**Planning Application: 6/2020/3420/MAJ**

**Major Development at BioPark, Broadwater Road, Welwyn Garden City, AL7 3AX**

## **“Broadwater Gardens”**

### **Public Consultation – Objections**

**BROADWATER GARDENS
PARKING PLAN - BASEMENT 02**

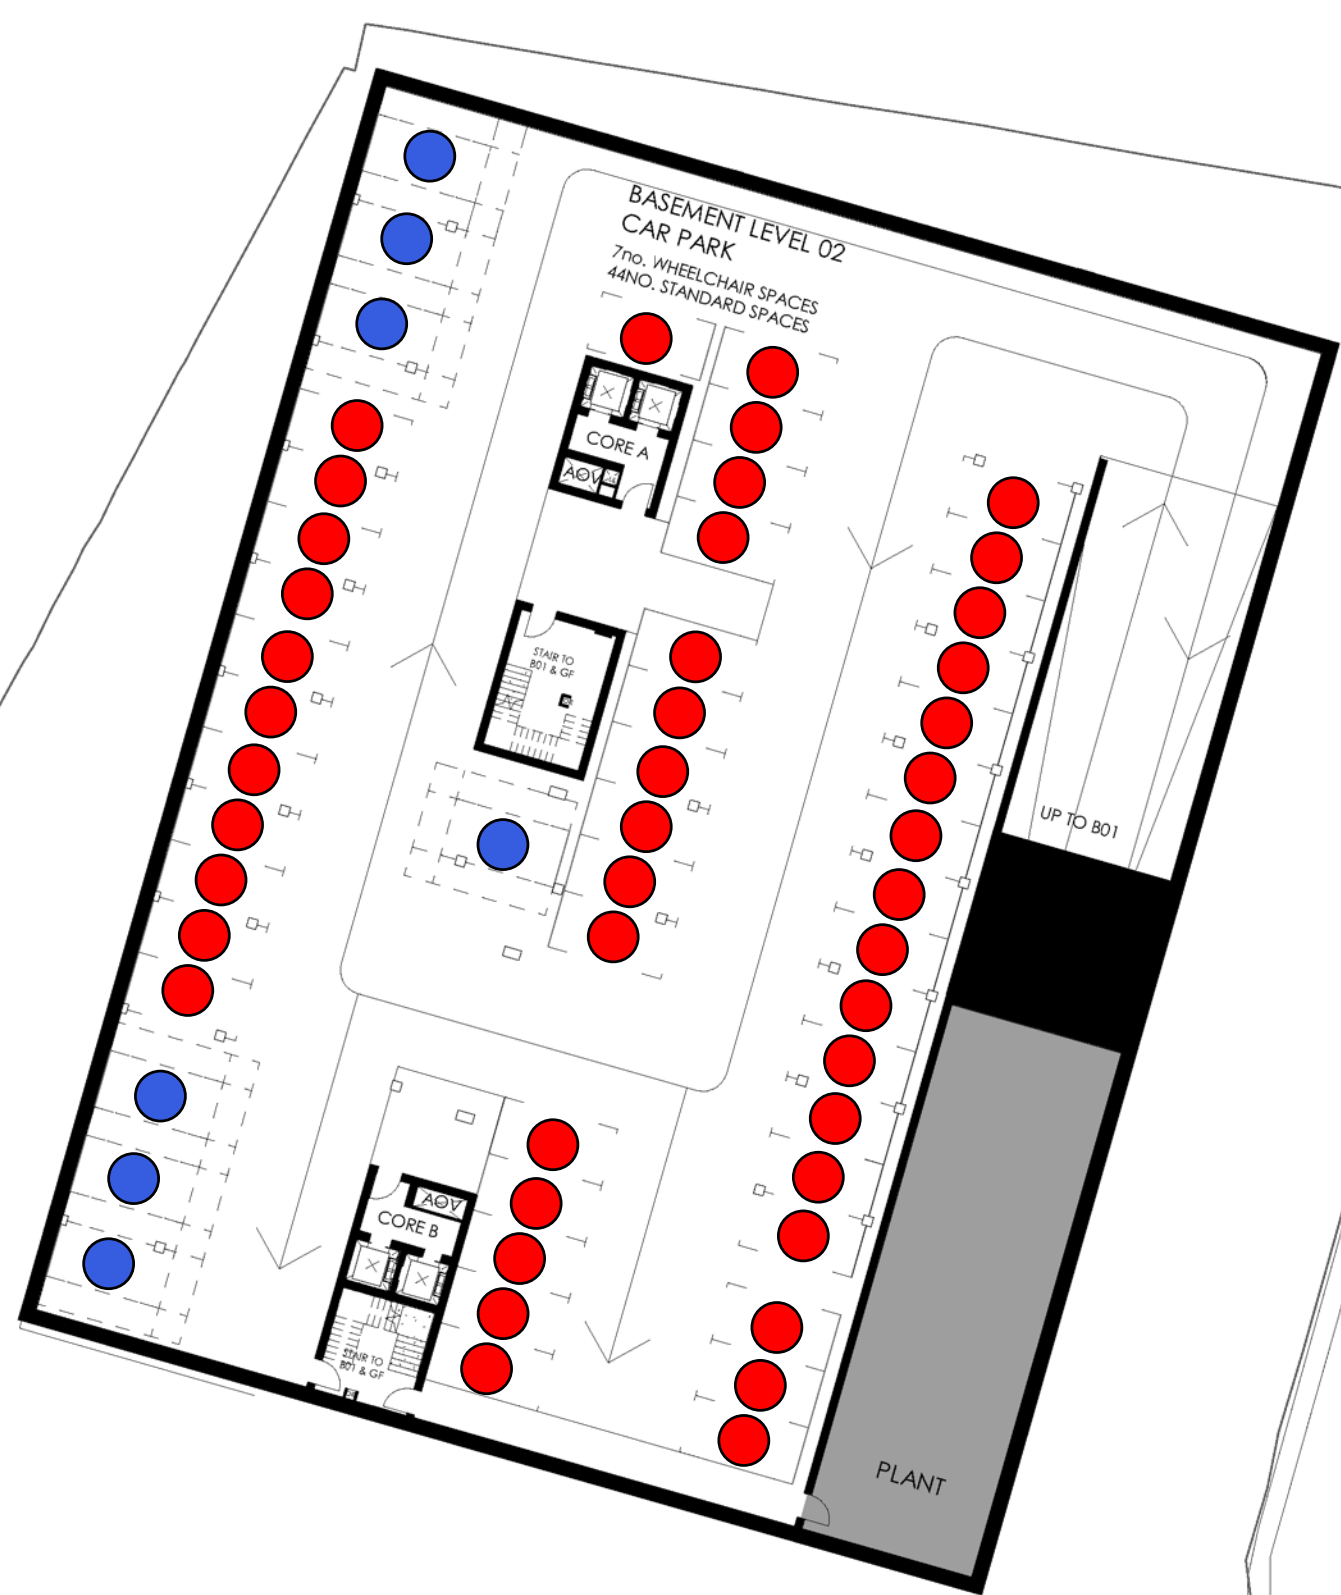
- It is not clear from the information provided that the external road space available and the single access ramp proposed for use by all traffic will allow unimpeded traffic flows into and out of the car park. Is two-way traffic supported?

- The vehicle height and width restrictions do not seem to be provided.
- The access ramp from the outside to basement level 1 is aligned such that it runs parallel to, but offset from, the ramp between basement level 1 and 2. This means that a vehicle entering or leaving the level 2 parking needs to make a 180 degree turn at level 1 to access the next ramp (see Block A & B Basement L01 Plan 010). It looks that a turning car will need the entire road space, ie. clear of any other level 1 or 2 traffic. What happens, if another car that will have been unsighted and coming in the other direction, is already on the next ramp?

- Whilst there is some segmentation of parking areas in the layout, there are also points at which traffic could be delayed by a driver needing to make a number of manoeuvres to park.
